From: Paul Cann
Sent: 06 February 2018 14:28
To: Juan Baeza
Subject: RE: Oakview (formerly Red Cottage); Arun District Council Planning Application WA/34/17/PL (Granted) and WA/78/17/DOC (Reserved Matters)

Comments;

Paul Cann
Senior Engineer (Drainage & Coastal)

| Drawing Title: | Site Plan Showing Below Ground Surface Water Drainage |

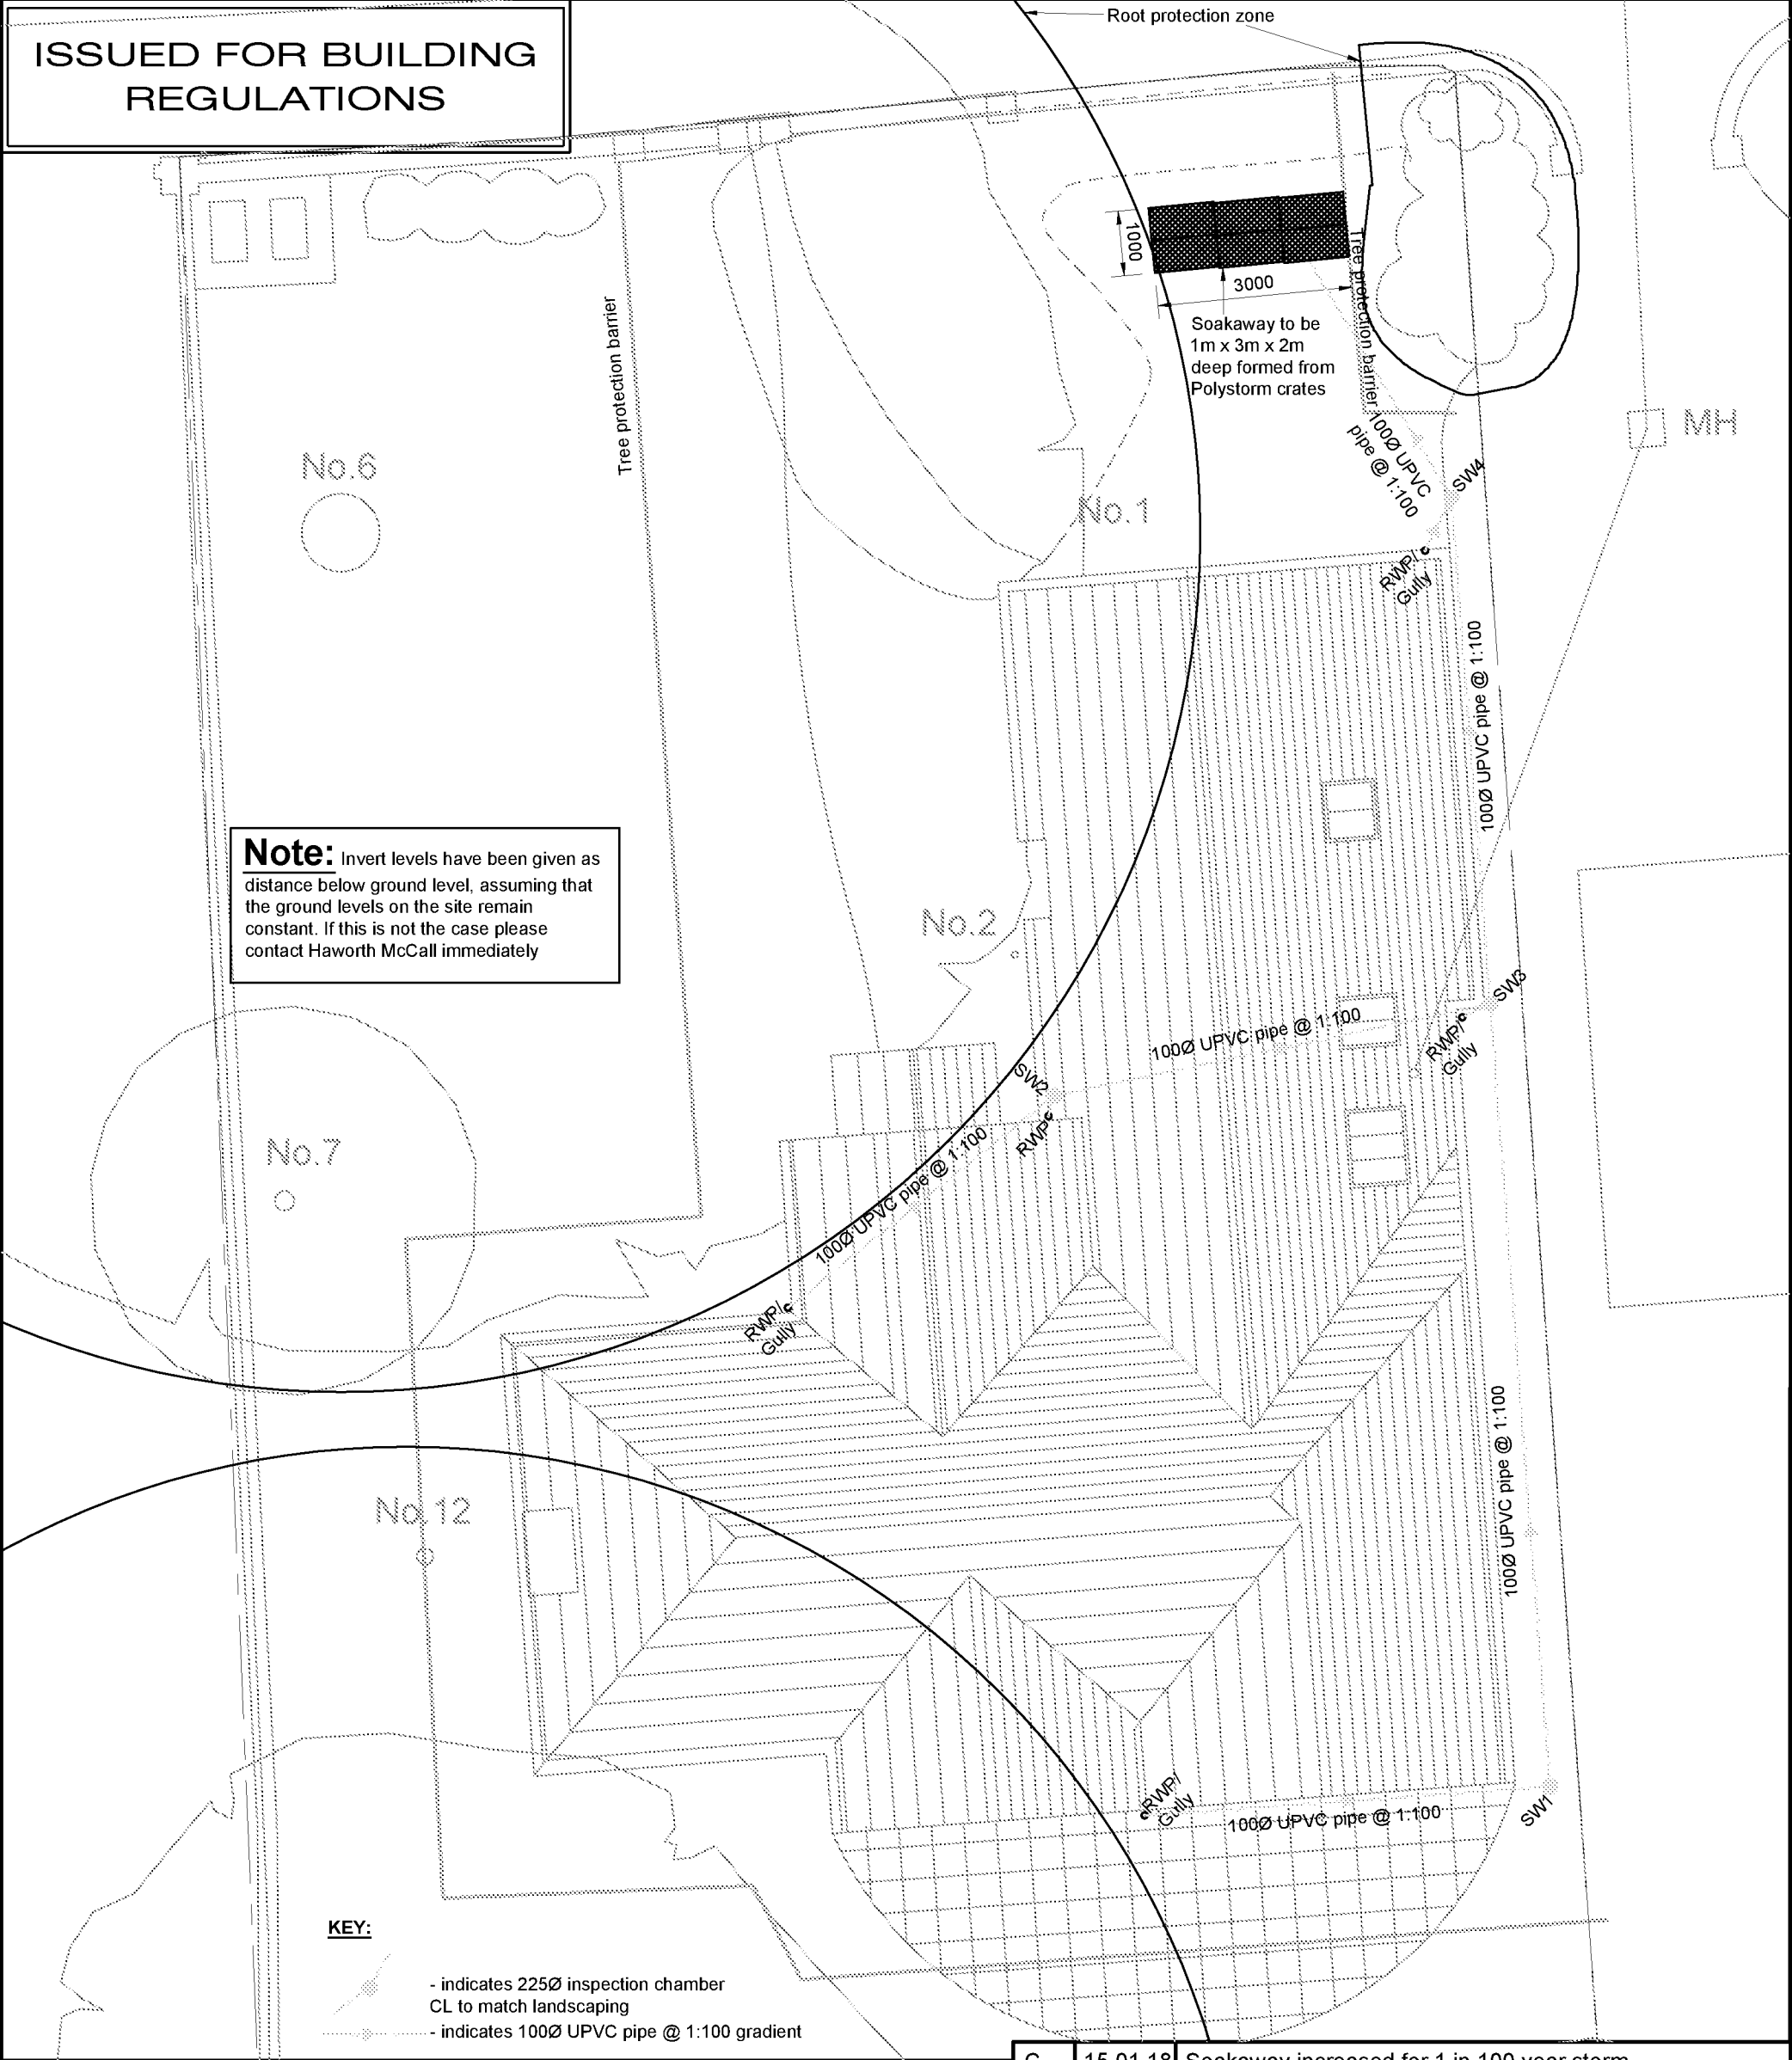
3. Channel drain – specify outlet pipe diameter/gradient and connection level to crates.
4. There is a significant slope on the on the permeable paving surface. In order to retain the water in the structure and prevent it from just running to the lowest end and coming to the surface, the formation level of the clean stone needs to be relatively level and therefore the depth of stone will increase as the finished levels rise. 200mm depth of stone needs to be achieved at the lowest end. The arrangement of this is also dictated by the root protection zone, so it needs to be made clear as to how the storage, etc is going to be fully achieved. Impermeable dams may need to be incorporated into the permeable pavement construction. Additional/revised cross sections should be provided to make it clear.

5. The permeable pavement edgings where the clean stone is shown above ground level will need to be a robust construction to prevent water escaping ie. Alter/provide details.
6. A permeable geotextile should be wrapped completely around the clean stone sub base to ensure that fines do not clog the stone.
